## City of Albuquerque Stormwater Construction Site Inspection Report

<b>Project Name and Location</b>	Assisted Curbs Curb Cuegra Abajo St & Cas Comites		
<b>Site Contact Name &amp; Agency</b>	Wayne	<b>Contact Phone #/ E-mail</b>	7
	<b>Date of Inspection</b>	6-14-17	<b>Start/End Time</b>
<b>Inspector Name, COA Dept.</b>	Curtis Cherne, Stormwater Quality		
<b>Inspector Phone / E-mail</b>	505-924-3420/ccherne@cabq.gov		
<b>Inspector Qualifications</b>	Qualified Compliance Inspector of Stormwater- Stormwater One		
<b>Describe Present Phase of Construction</b>	Stabilized

Project Name and Location	Assisted Living Center Cuesta Abajo & Las Lunetas	ESC PERMIT #	
Site Contact Name & Agency	Wayne	Contact Phone #	
Date of Inspection	9-11-15	Start/End Time	10:15/10:30
Inspector Name, COA Dept.	Curtis Cherne, Stormwater Quality		
Inspector Phone / E-mail	505-924-3420/ccherne@cabq.gov		
Inspector Qualifications	Stormwater USA		
Describe Present Phase of Construction	fine graded, one bldg, parking lot constructed		
Type of Inspection:	<input type="checkbox"/> Regular <input type="checkbox"/> Drive-By/Random <input type="checkbox"/> During storm event <input type="checkbox"/> Post-storm event <

**PHASE I
EROSION AND SEDIMENT
CONTROL PLAN**

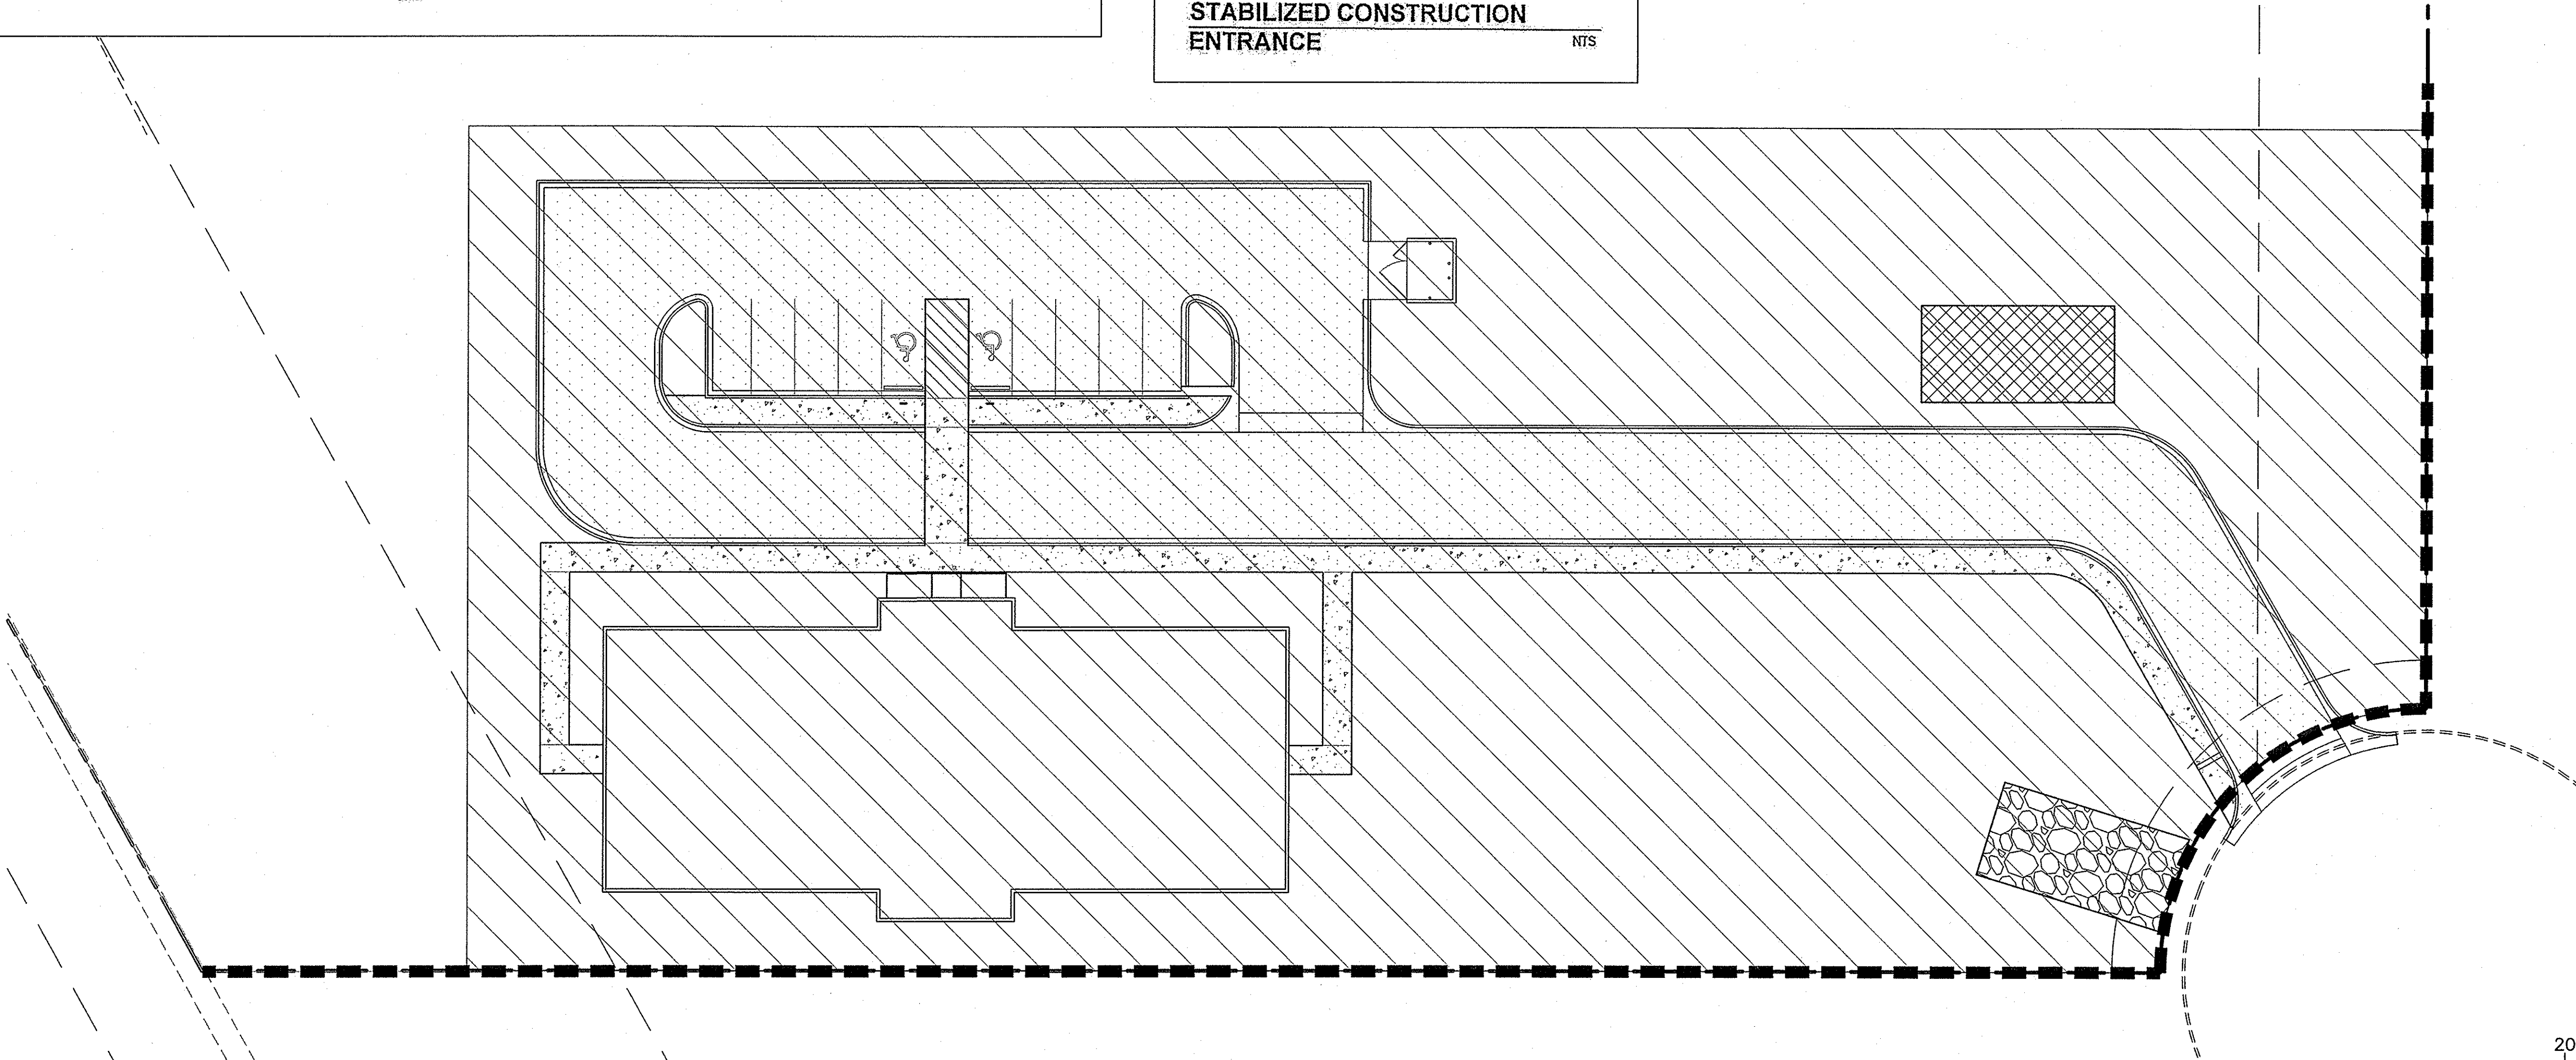
- Entrance / Off Tracking    track-out from area east of access RA
- Sediment Controls / Silt Fence, Check Dams, Waddles, etc.    NO BMPs, Sediment in cul-de-sac
- Erosion Controls / Mulch, Seed,    NO
- Wind Blown Erosion    NO
- Housekeeping / Pollutant Controls    Numerous concrete wash-outs SE corner
- paint dumped on ground east central area

- Entrance / Off Tracking OK
- Sediment Controls / Silt Fence, Check Dams, Waddles, etc. added
- Erosion Controls / Mulch, Seed, NO
- Wind Blown Erosion NO
- Housekeeping / Pollutant Controls good - cleaned up site
- Spoke w/ Diane and Wayne Sr., stopped by to discuss erosion no photos
